DEVELOPMENT PLANS FOR MARRIOTT RESIDENCE

ADDISON, TEXAS

PROJECT NAME Marriott Residence

STORM SEWER OUTFALL MODIFICATION
MARRIOTT RESIDENCE
ADDISON, TEXAS

GRADING PLAN & STORM SEWER PLAN

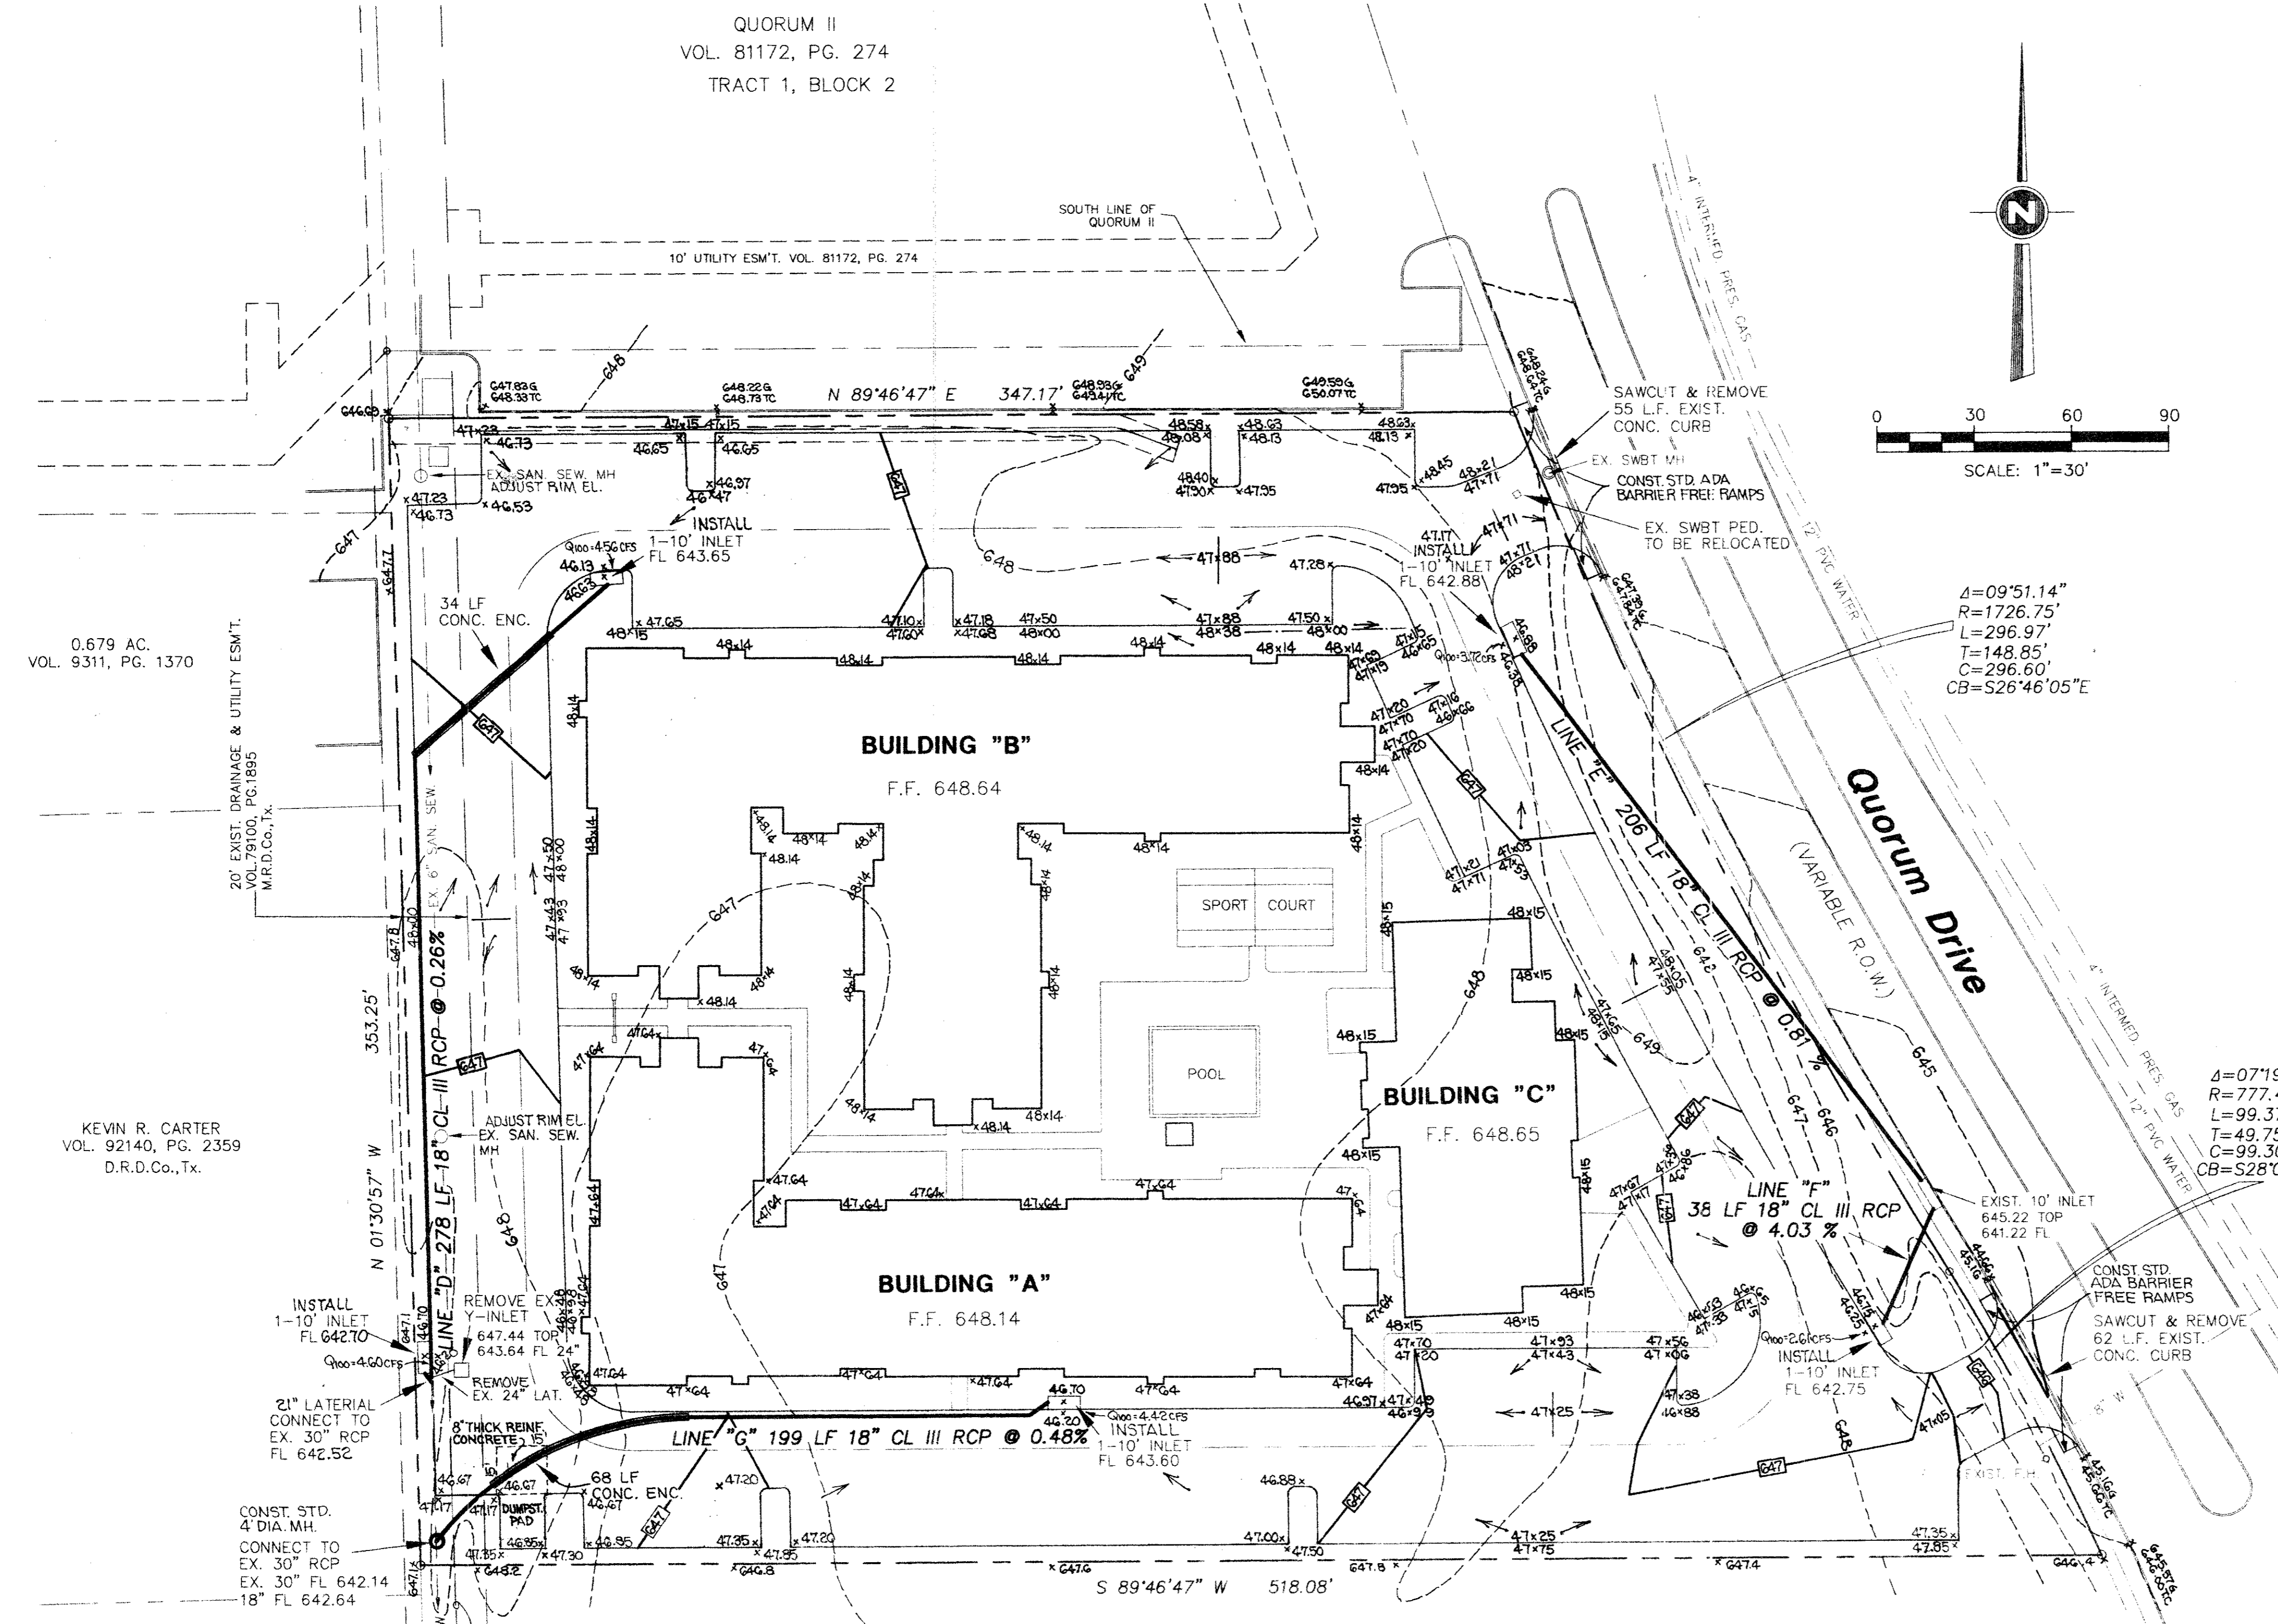
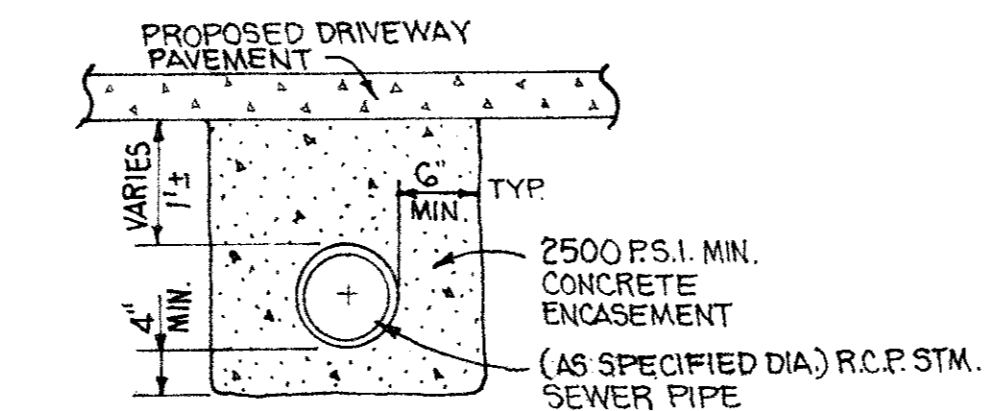
We have found that the existing 30 inch diameter storm sewer pipe at the southwest corner of the project was not installed to the grades per the plans by others. We obtained existing grades at five locations by survey on the 30" diameter pipe at approximately 50 feet intervals. It is apparent that approximately 204 L.F. of the existing 30" diameter pipe needs to be re-installed. The proposed 24 inch diameter RCP has the required capacity of the Marriott project and allows additional capacity to .5 acres minimum on the area of the undeveloped tract to the adjacent southern boundary. There is blue rock existing in this area of the existing 30" diameter pipe As you know, this project is under construction and has been stalled due to resolving this utility problem. Your review and assistance is greatly appreciated.

204 L.F. EX. 30" DIA. RCP TO BE REMOVED
PROP. 204 L.F. 24" DIA. CL. III RCP @ 0.48%

REMOVE EX. Y-INLET
647.44 TOP
643.64 FL 24"
Q_{max} = 4.60 cfs
REMOVE EX. 24" LAT.
